WEST SUSSEX COUNTY COUNCIL CONSULTATION

TO:	Arun District Council FAO:David Easton
FROM:	WSCC - Highways Authority
DATE:	12 August 2021
LOCATION:	Land South of Summer Lane & West of Pagham Road Pagham
SUBJECT:	P/83/21/DOC Approval of details reserved by condition imposed under ref P/140/16/OUT relating to Condition No 6 - design code masterplan. An amendment received.
DATE OF SITE VISIT:	n/a
RECOMMENDATION:	Advice
S106 CONTRIBUTION TOTAL:	n/a

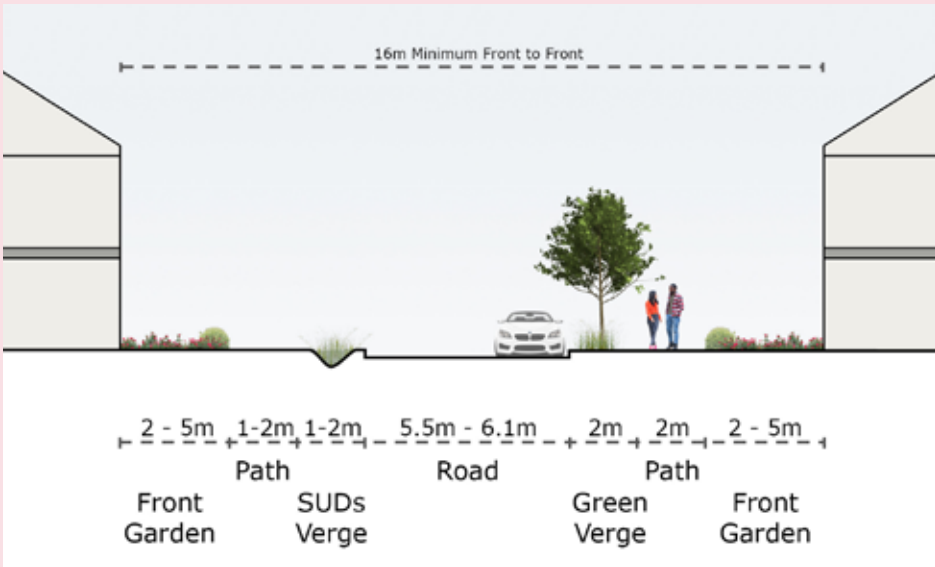
P45 – With the shared surface cross section, if the shared surface is to be offered for adoption the applicant should note that margins would be required on both sides of the shared surface. For adoptable areas, the margins should be a minimum of 500mm wide. The expectation is that the margins would be of sufficient width to avoid any services being placed within the shared surface itself.

As noted already, details of margins alongside shared surfaces are covered by the details on P28. However the actual street cross sections do not reflect these with the required margins potentially encroaching significantly into front gardens.

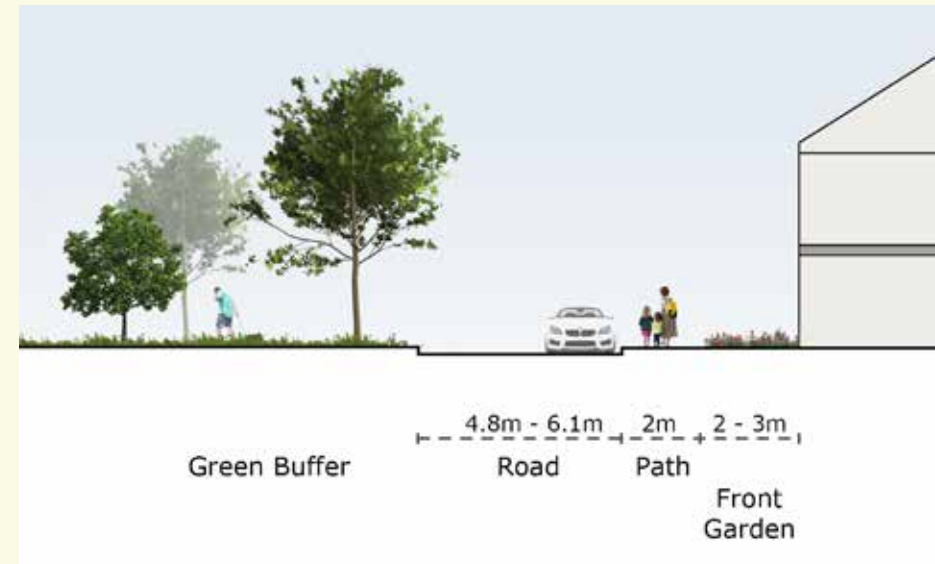
P57, P61, P65 – Similar to the above point, margins would be required along both sides of the shared surfaces if these are to be adopted as public highway.
